Your Ref :
Our Ref : BN/47/18/NMA

Section 96A of the Town & Country Planning Act 1990 (as amended)
Town and Country Planning (Development Management Procedure) (England) Order 2015 (as amended) - Article 10

Non material amendment following the grant of BN/69/16/PL for plot 1-amended internal layout & re-positioning of rear patio area & omission of chimney; plot 2-addition of roof gable above entrance door, re-positioning of rear patio area & adjustment of adjacent driveway; plot 5-omission of bay window & substitution of french doors to north west elevation.
Land East Of Toll Cottage, Lake Lane, Barnham,

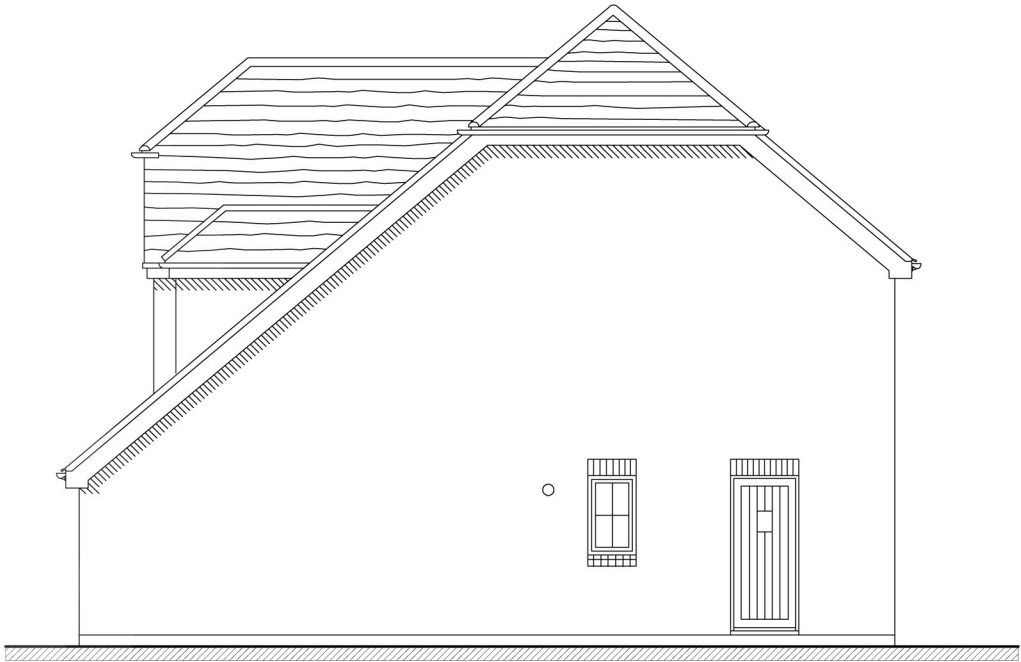
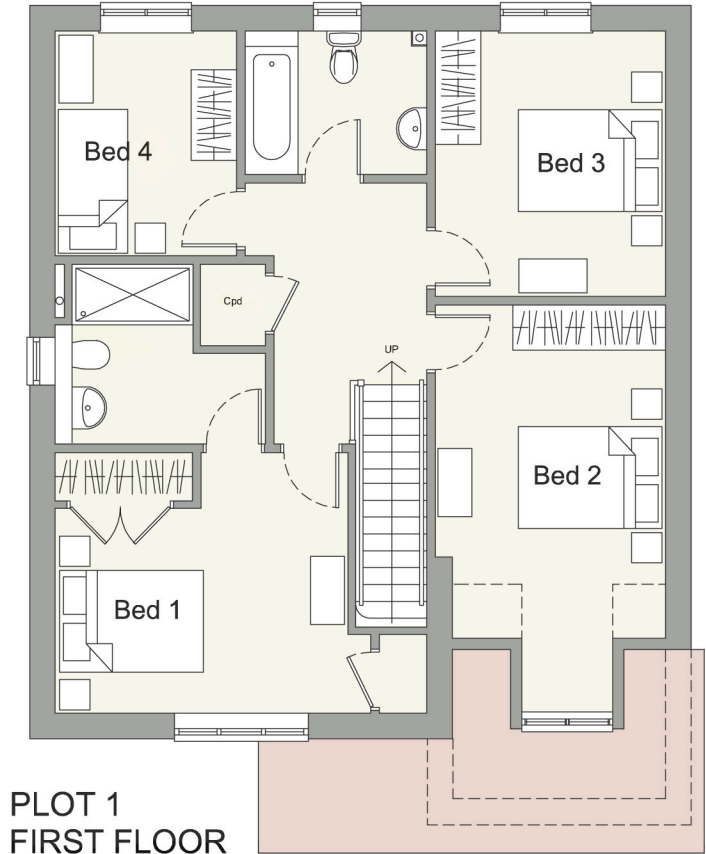
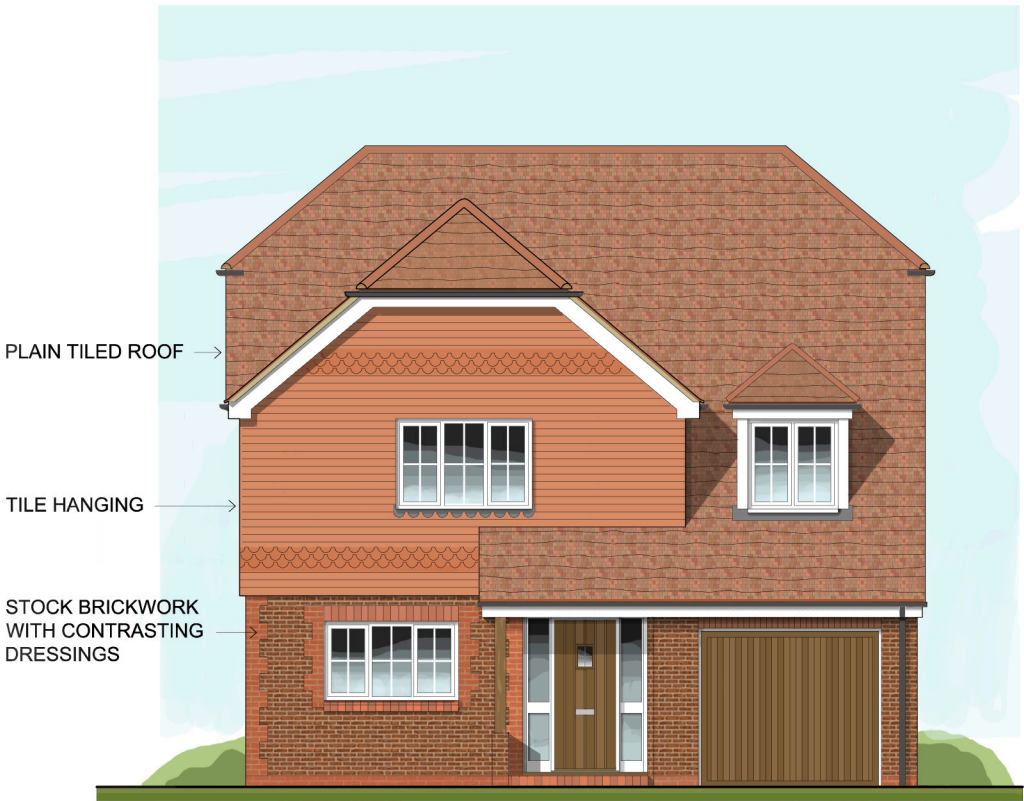
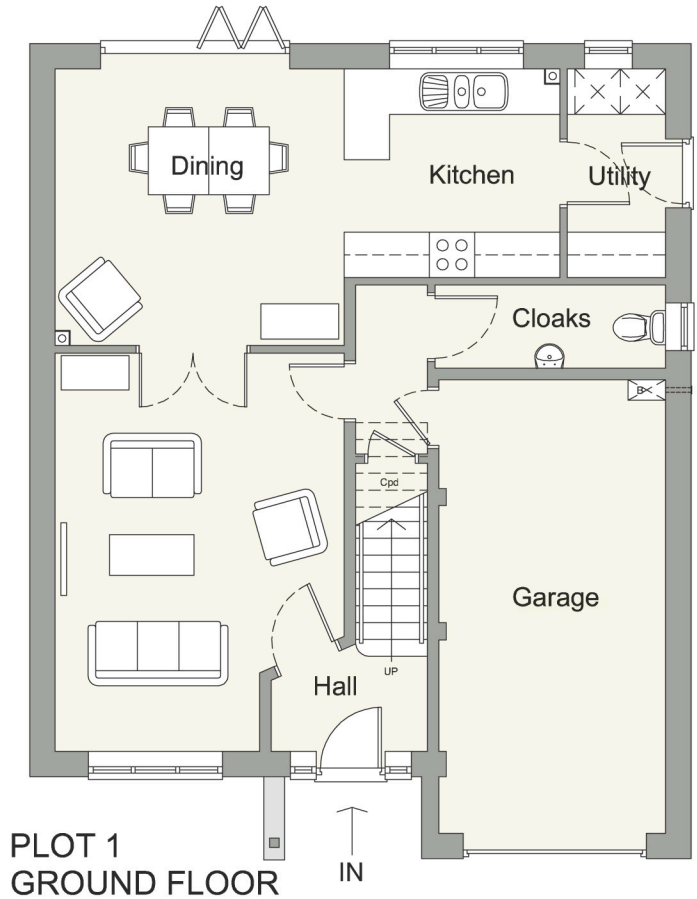
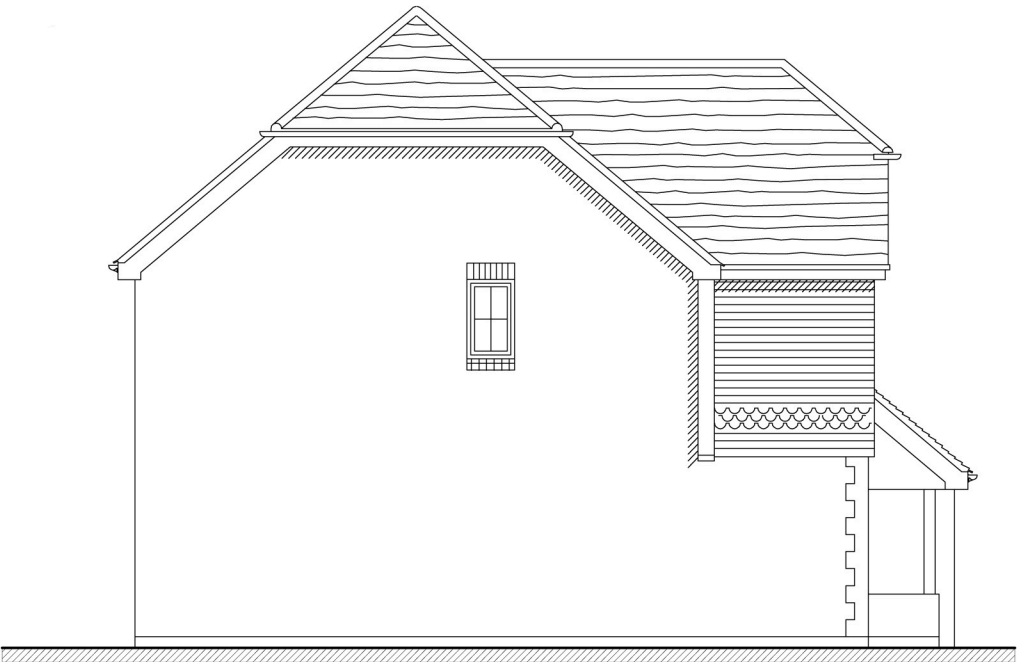
- (a) Plot 1 - amend the internal house layout, remove the external chimney stack and reposition the rear patio area;
- (b) Plot 2 - add a feature roof gable above the entrance door, reposition the rear patio area and adjust the adjacent driveway; and
- (c) Omit the bay window and add French doors to the north west elevation.

Dwg. 30 Rev D: "Site Plan" - Now Rev E;
Dwg. 31 Rev B: "Plot 1 Floor Plans & Elevations" - Now Rev C;
